**WELWYN HATFIELD BOROUGH COUNCIL
EXECUTIVE DIRECTOR - PLANNING, PUBLIC PROTECTION AND GOVERNANCE**

Application No: 6/2020/1681/HOUSE
Location: 36 Vineyards Road Northaw Potters Bar EN6 4PA
Proposal: Erection of first floor extension over existing garage, removal of existing chimney, alterations to fenestration, enlargement of existing outbuilding and creation of swimming pool and terrace area.
Officer: Ms Emily Stainer

Recommendation: Refused

Proposed Elevations

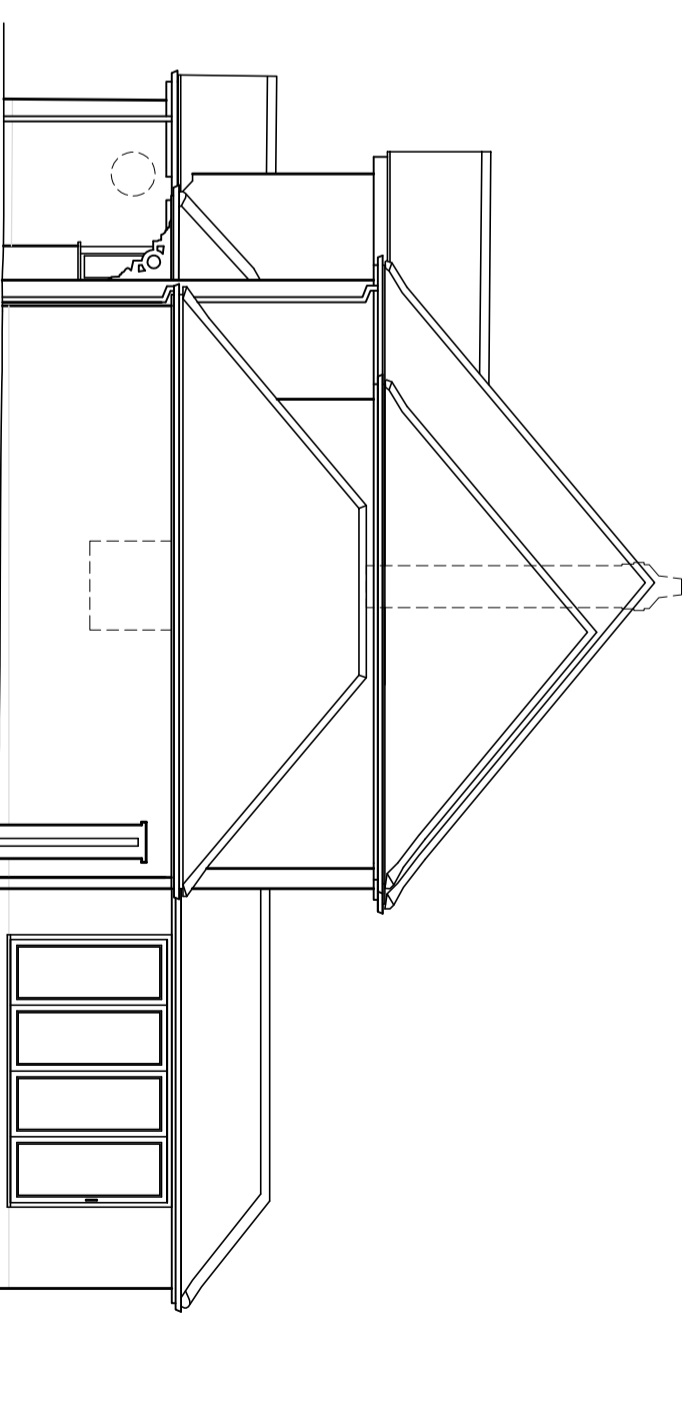
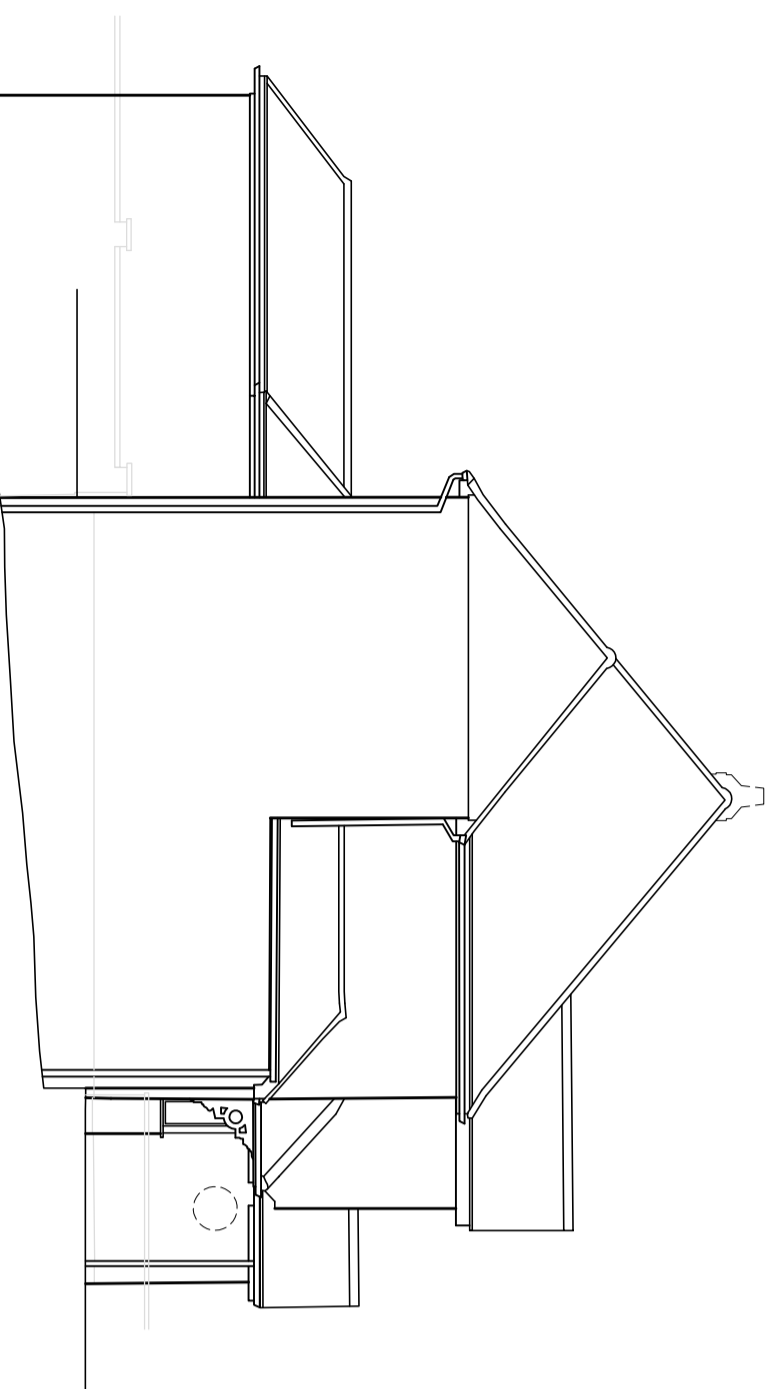
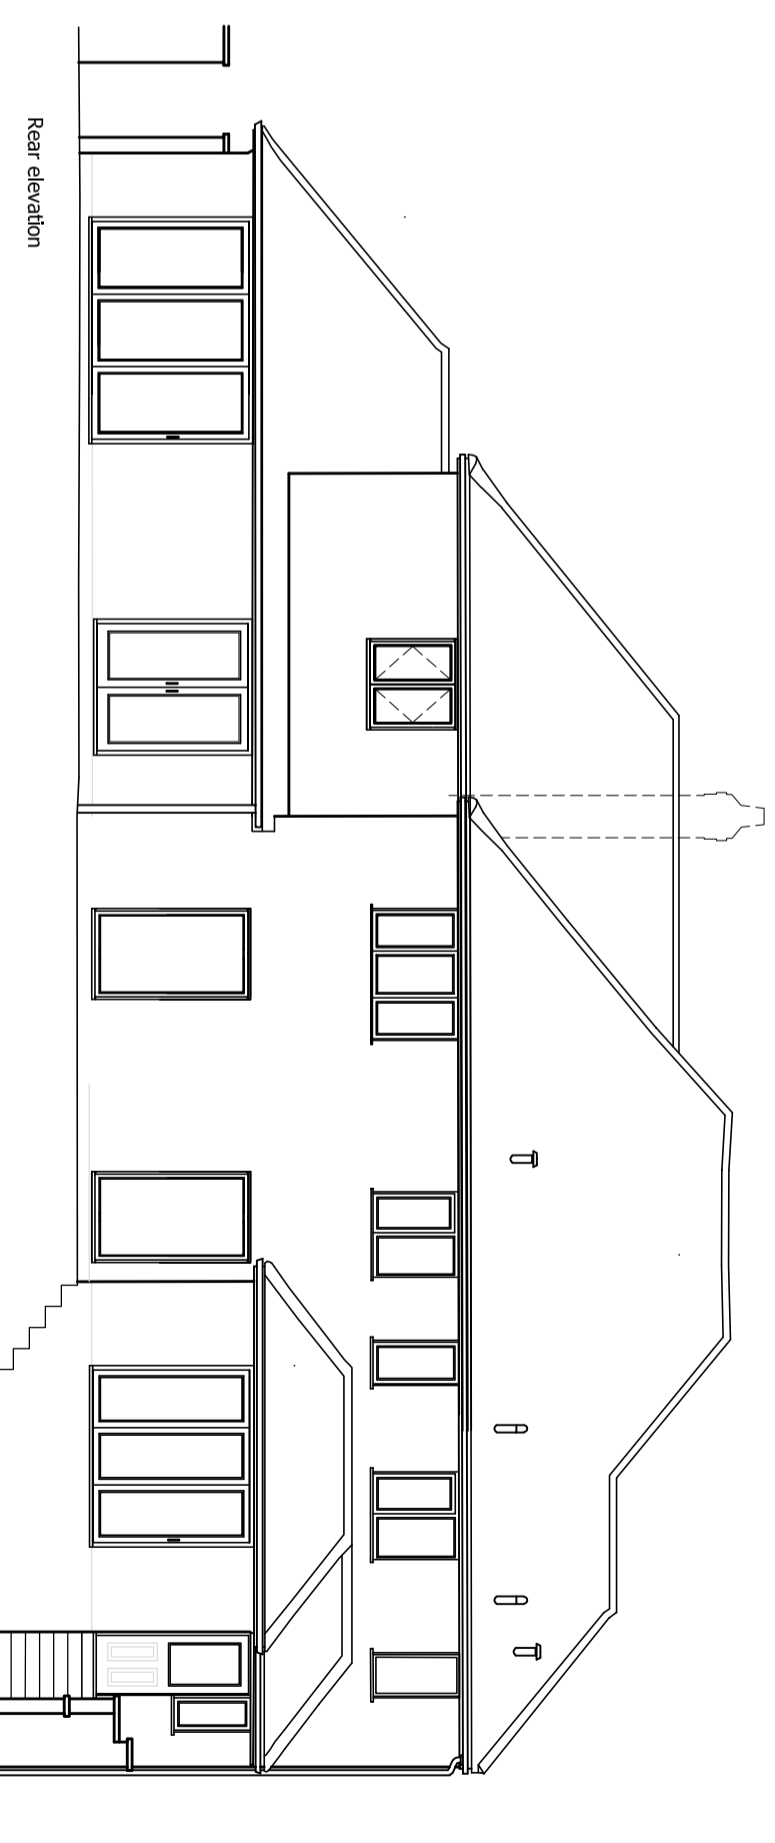
In this regard, the proposed extension would be at first floor level in height, in addition to the original property benefitting from an existing first floor side extension. When taking into account the cumulative extent of the extensions to the original building, this proposal would result in additions that extend the original building to a significant degree. The resultant scale and mass of the building would subsequently fail to respect its original size and form. Consequently, in a visual sense as well as numerically, the proposal would result in disproportionate additions contrary to paragraph 145 of the NPPF. The NPPF confirms that inappropriate development is by definition harmful to the Green Belt and this is afforded substantial weight.

In terms of the effect of the first floor side extension on the openness of the Green Belt, the proposed increase in volume and floor area would materially increase the bulk and mass of development on the site thereby reducing the openness of the Green Belt to a degree. The design and siting of the extension to the side which would be visible from the front of the site would appear highly visible from the streetscene of Vineyards Road. The site is located within a small built up area of the Green Belt forming ribbon development out of the village, in which there is evidence of two storey side extensions. Whilst it is considered that there would be a significant increase in the amount of built development to the original dwelling, given the context and character of the immediate area, the negative effects on the openness of this part of the Green belt would be moderate. This moderate harm is in addition to the harm by reason of inappropriateness however, which is afforded substantial weight.

<p>windows would primarily allow views within the site and not result in a significantly different relationship to the existing openings.</p> <p>Only limited information has been provided regarding the proposed swimming pool and terraces to the rear due to a lack of sectional or elevational details being submitted which indicate the proposed height and land levels. As the closest neighbouring property to the proposed swimming pool and terrace (38 Vineyards Road) is set significantly further back from the road using a separate private access road, and the property benefits from dense boundary vegetation screening it from this access, the proposal is unlikely to result in a loss of privacy. Nonetheless, insufficient information has been provided to enable the case officer to make a definitive assessment of this. Further details regarding the height and existing land levels should be submitted as part of any amended planning application.</p>

3. Insufficient drawings have been submitted with the application to adequately assess the impact of the proposed swimming pool and terrace on the Green Belt and the privacy of neighbouring properties against Policies GBSP1 and D1 of the Welwyn Hatfield District Plan 2005; Supplementary Design Guidance 2005; Policy SADM11 of the Welwyn Hatfield Borough Council Draft Local Plan 2016; and the National Planning Policy Framework.

Extension to existing outbuilding

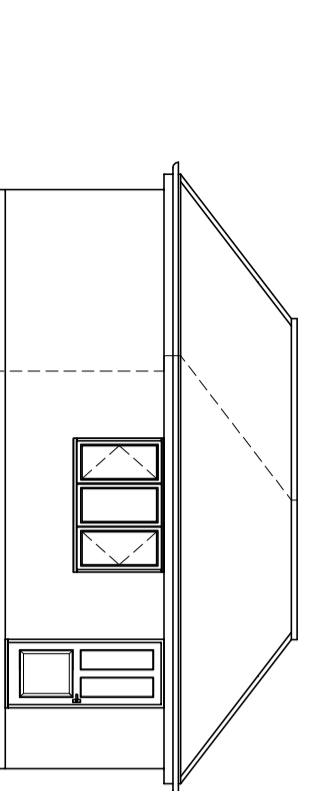
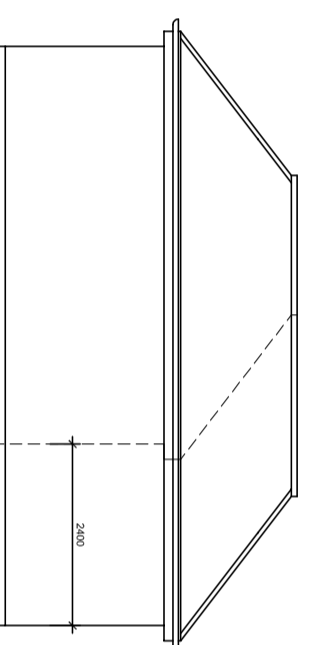
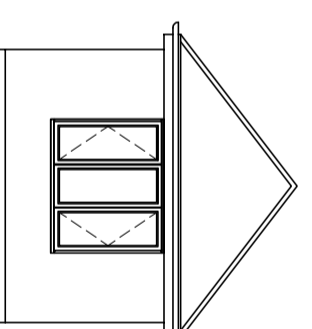
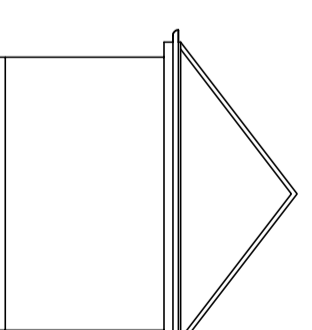
Paragraph 146 of the NPPF states that certain other forms of development that are not listed within paragraph 145 may also be acceptable within the Green Belt as long as they preserve the openness of the Green Belt and do not conflict with the purposes of including land within the Green Belt. It is considered that the relevant exception for the proposed swimming pool would be within 146(b), as it would be primarily an engineering operation. No elevational/sectional drawings have been provided of the proposed swimming pool and surrounding terrace to indicate the existing and proposed levels. The case officer is therefore unable to make an assessment as to whether this aspect of the proposal would meet the limitations set out within paragraph 146.

Proposed Floor Plans

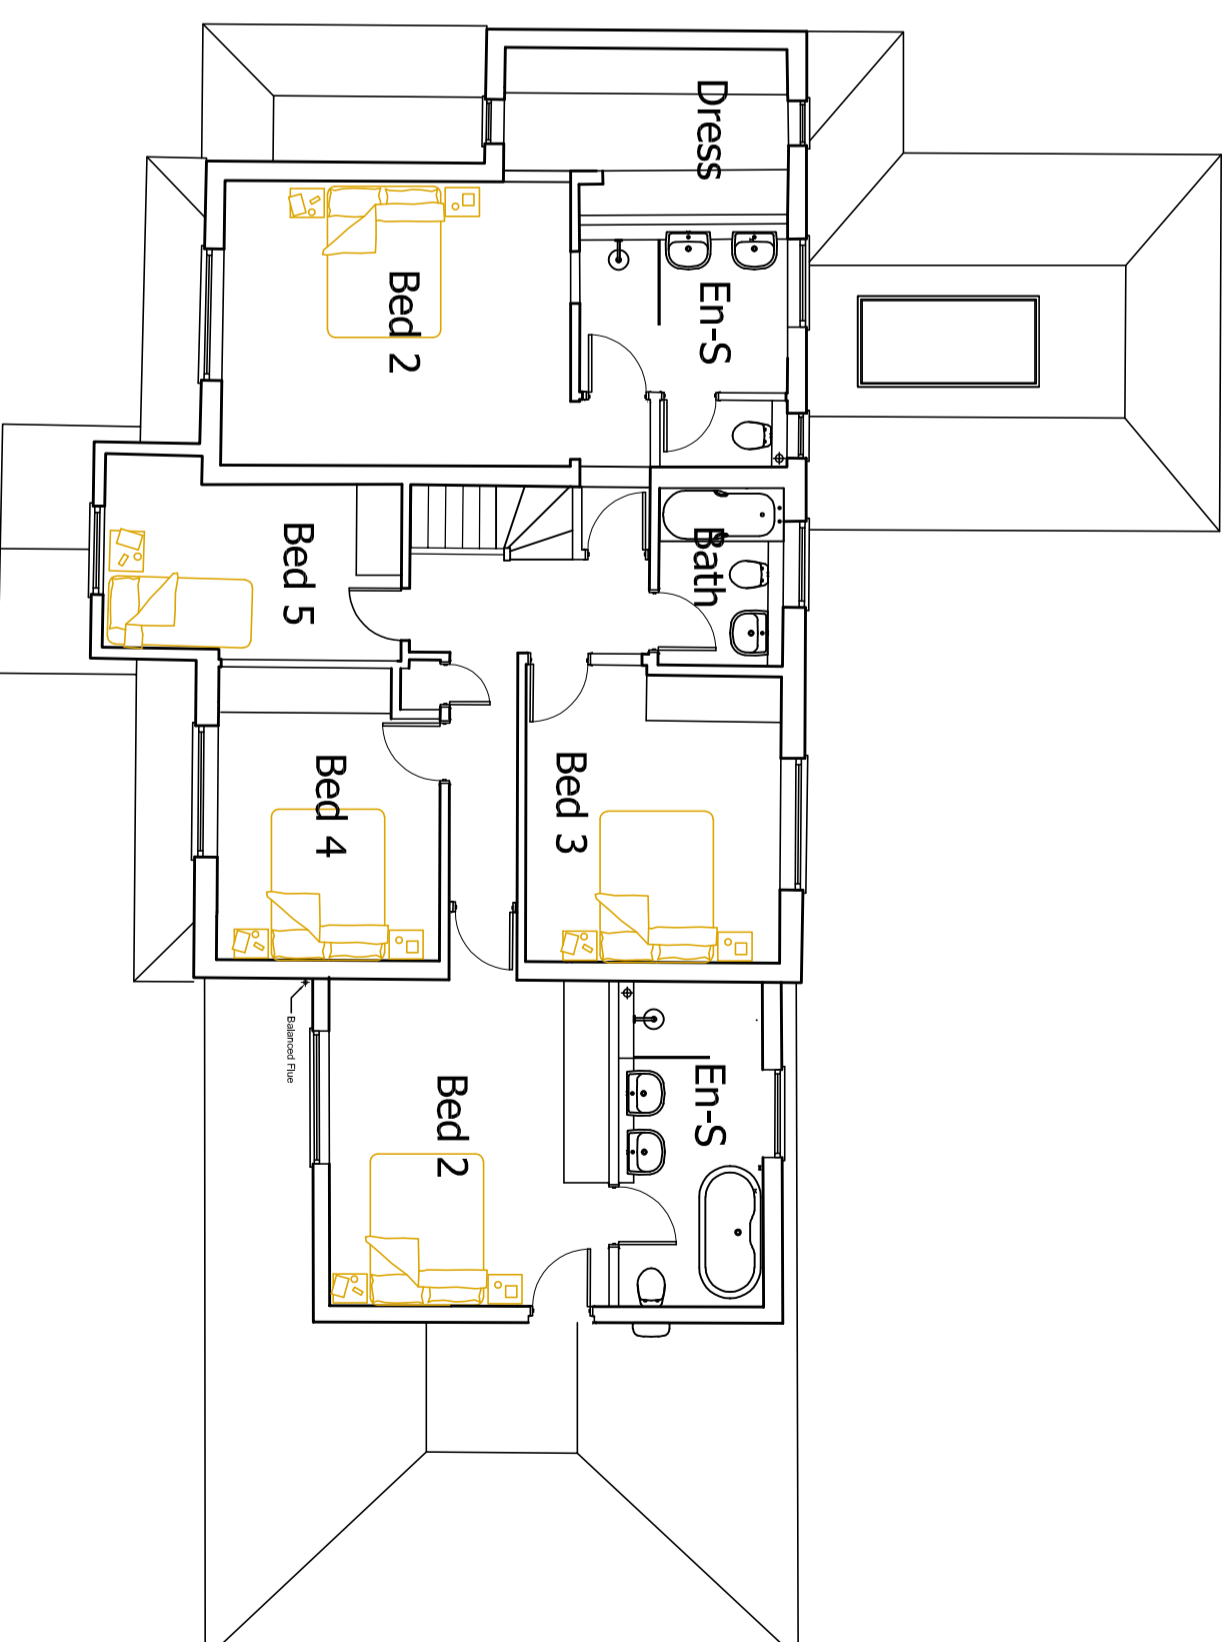
The original building has been extended significantly, including numerous single storey extensions and a first floor side extension (see relevant planning history). Historic planning applications indicate that the original floor area of the dwelling appeared to measure approximately 173sqm. Using the submitted plans, the existing floor area of the property measures approximately 295.5sqm (taken externally), representing an increase of approximately 70.8% over the original property. The proposed first floor side extension would add approximately 28.5sqm to this figure, resulting in an 87.3% percentage increase above the original dwelling. Policy RA3 additionally notes that it applies to outbuildings for which planning permission is required. Planning permission is sought for the extension of the existing outbuilding and the proximity of the outbuilding to the dwelling suggests it should also be included in the above calculations. The extension of the existing outbuilding would result in a building measuring approximately 7.7m x 3.6m with a floor area of approximately 27.72sqm. This figure increases the total floor area to a 103.3% increase above the original dwelling. It is therefore considered that this further contributes to the disproportionate nature of the existing and proposed extensions compared to the original property.

As such, although the proposed extensions to the property and outbuilding would only result in a combined floor area of approximately 37.14sqm over the existing situation, the dwelling has already been extended beyond what could reasonably be considered proportionate, taking a purely arithmetic viewpoint. The proposed extensions, together with those existing, would therefore result in substantial additions to the building.
